From: Anita Gardner
Sent: 04 September 2020 16:18
To: Planning.Responses
Subject: FW: LU/214/20/PL

LU/214/20/PL

The site

The Proposal

Elevation G' | East Street Scale 1:100 @ A0

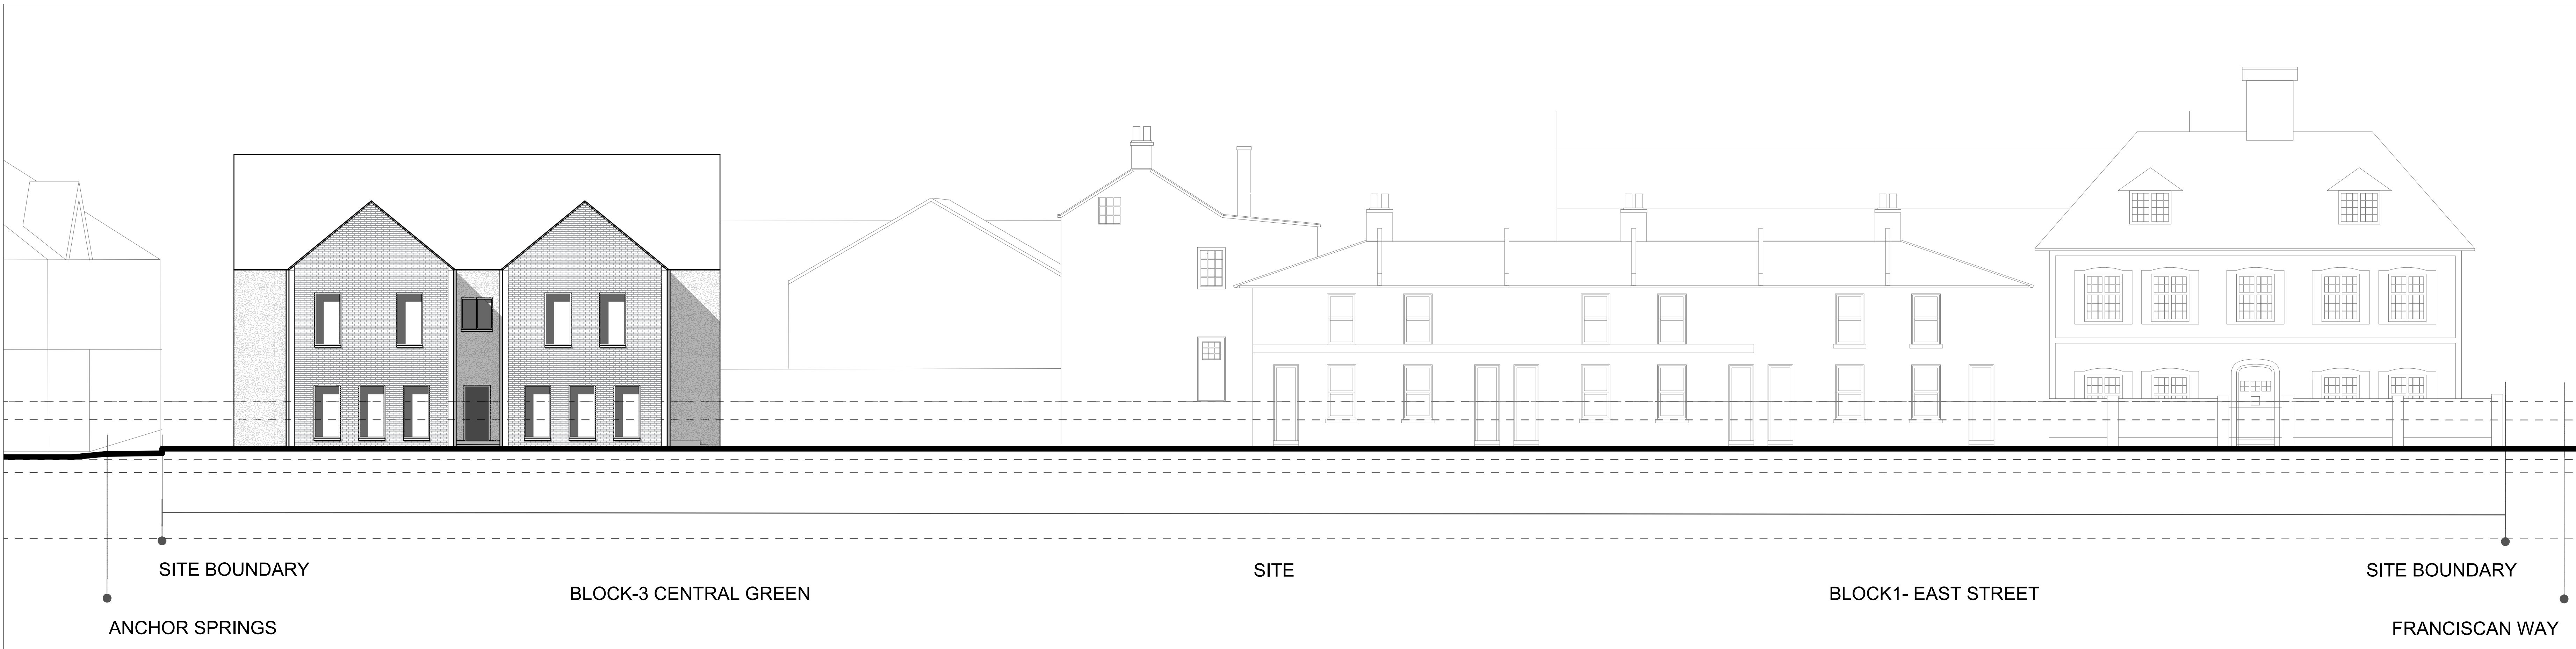
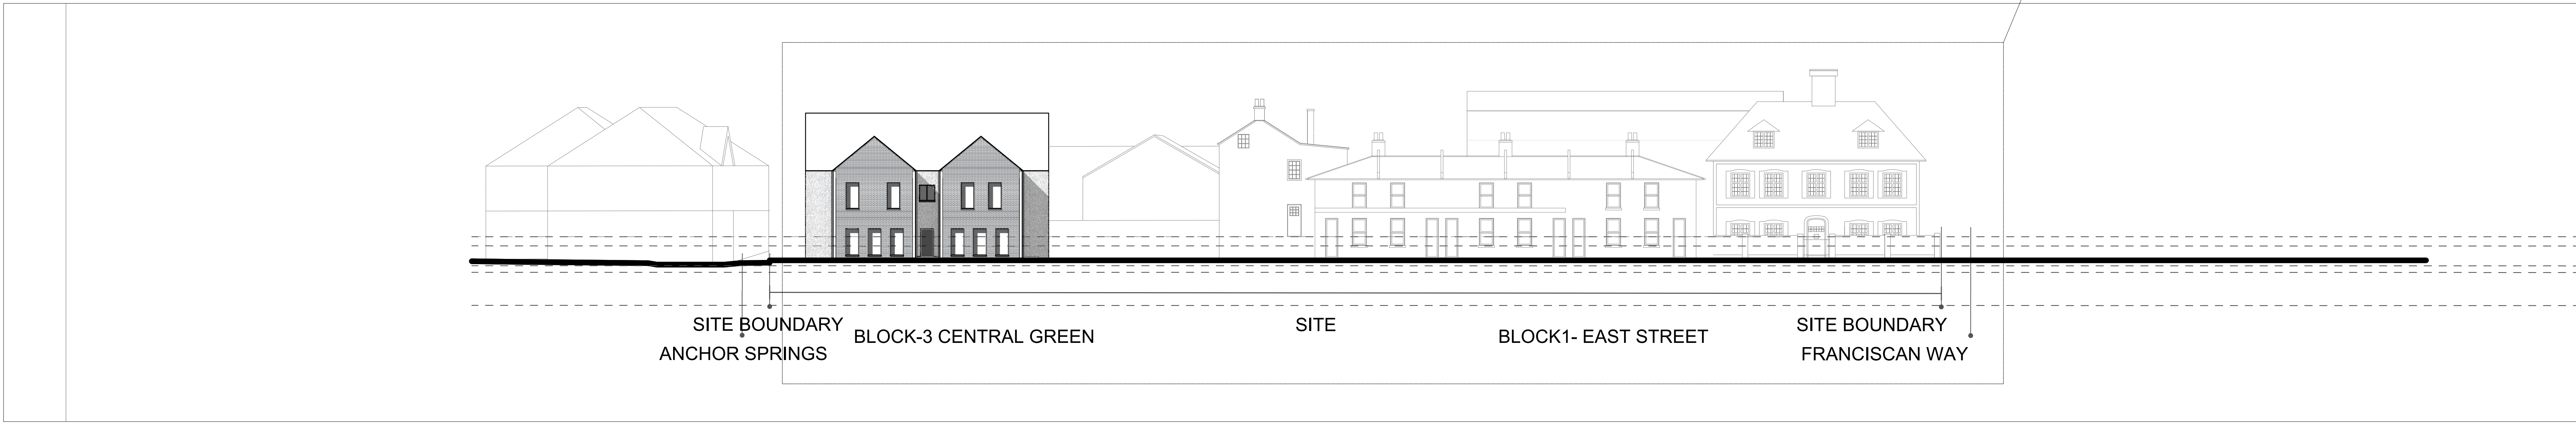
Whilst the reference to the use of gables is noted, it is not fully clear how the remainder of the proposal reflects the local vernacular in terms of the building form, materials, design and detailing in a contemporary and innovative way. For instance, the block fronting East Street and the conservation area appears out of keeping with the buildings in the local area in terms of its configuration, massing, form, and fenestration treatment

Whilst the proposal introduces variations in building line and height in order to reduce the impact, I am concerned that the 3 storey elements of the buildings will appear overbearing in relation to the street scenes, especially in Franciscan Way, Avon Road and East Street. This is also detrimental to the settings of the Conservation Area and some of the Listed Buildings (such as Avon House)

Elevation E | Avon Road Scale 1:100 @ A0

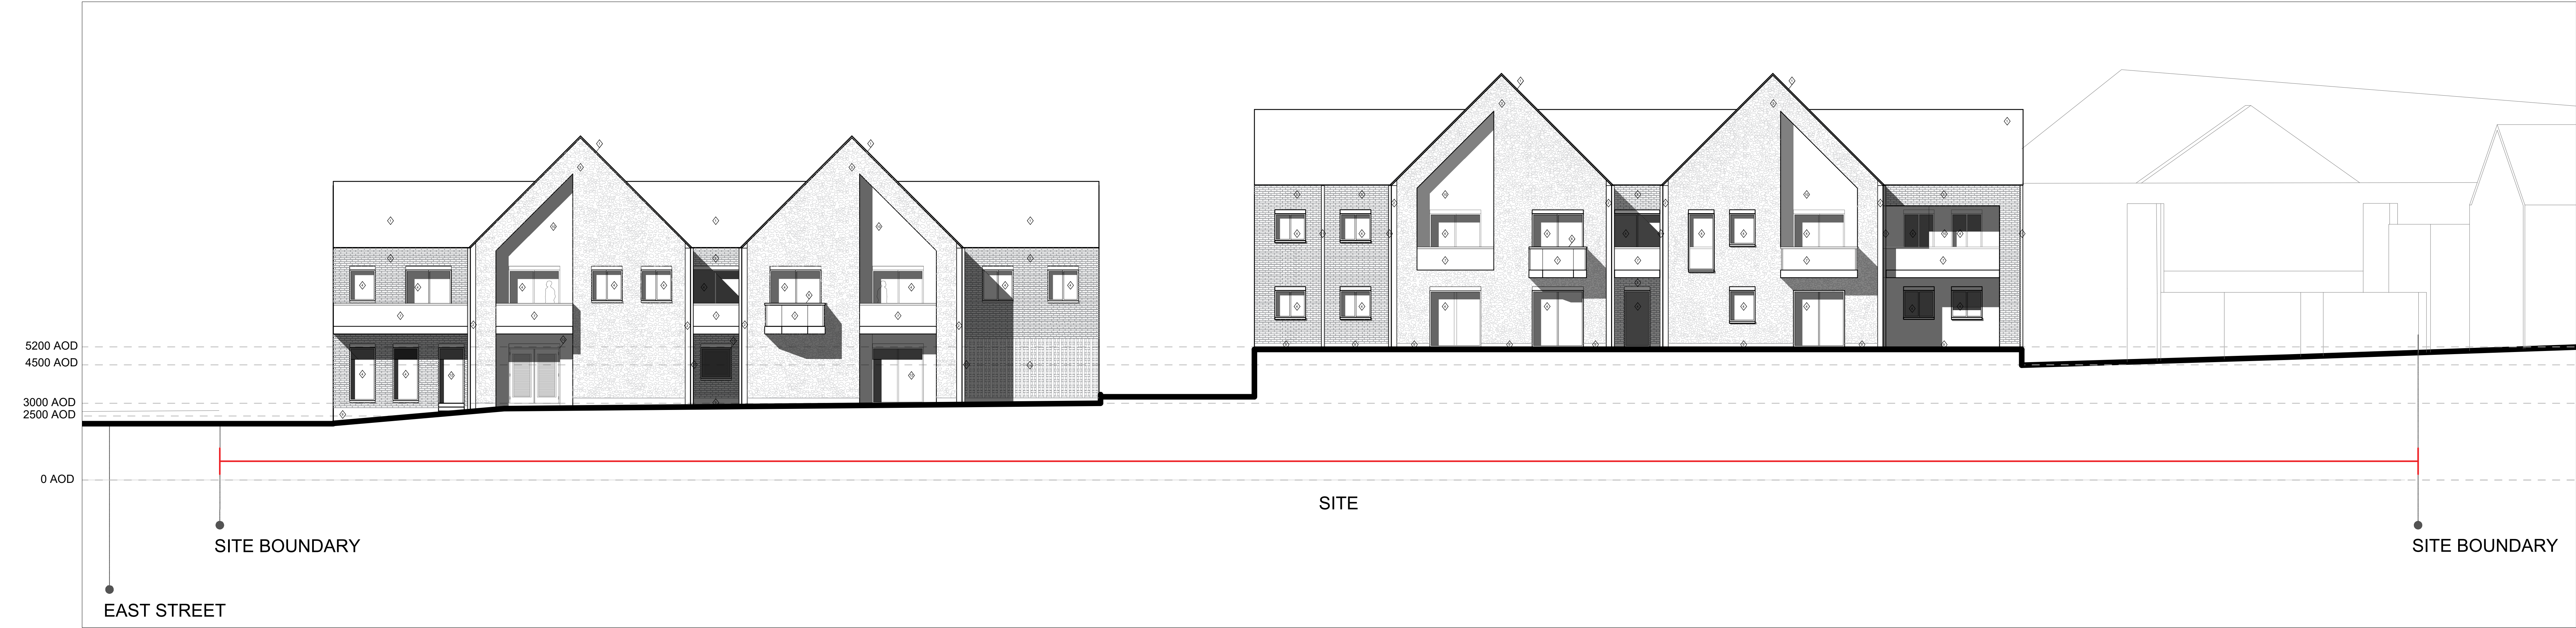
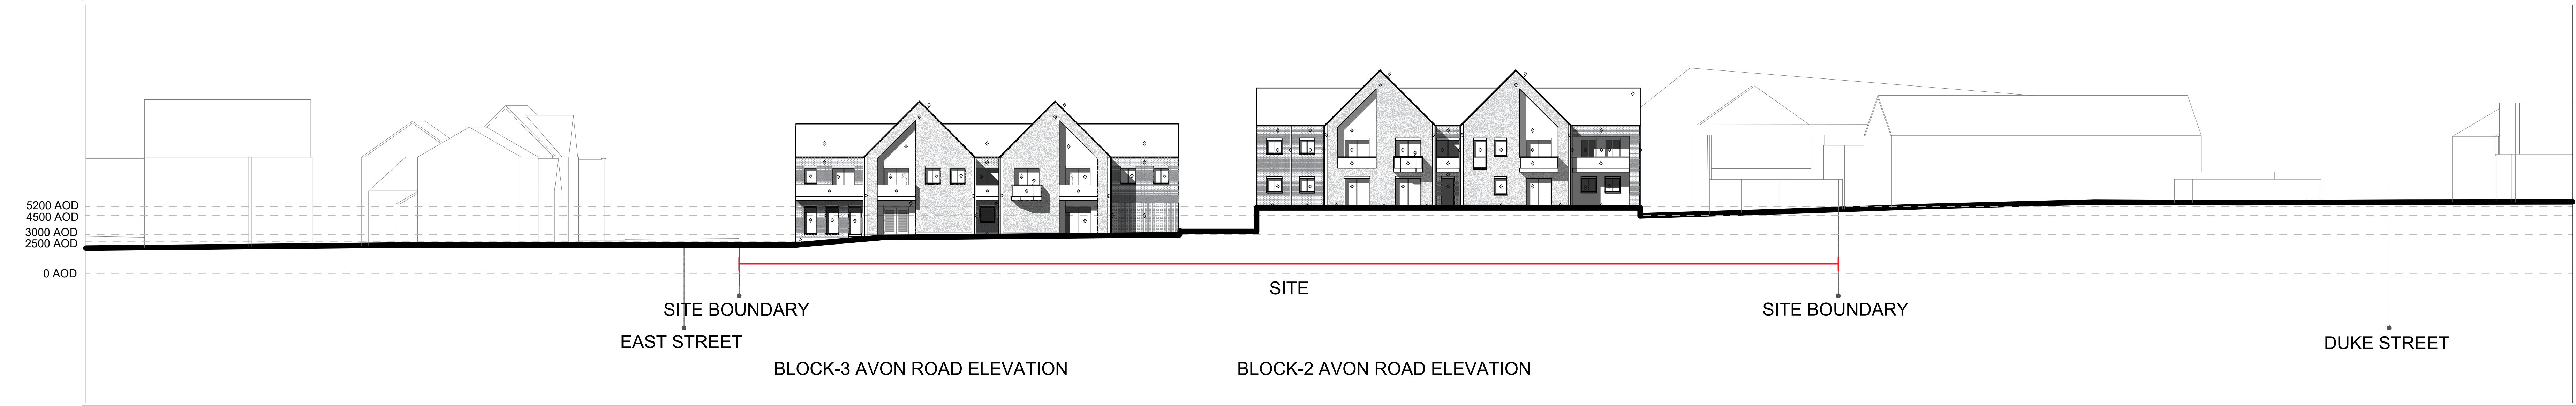
The proposed parking opposite Avon House is also a concern as it will compromise its setting. Could this area be used as some form of landscaping instead?
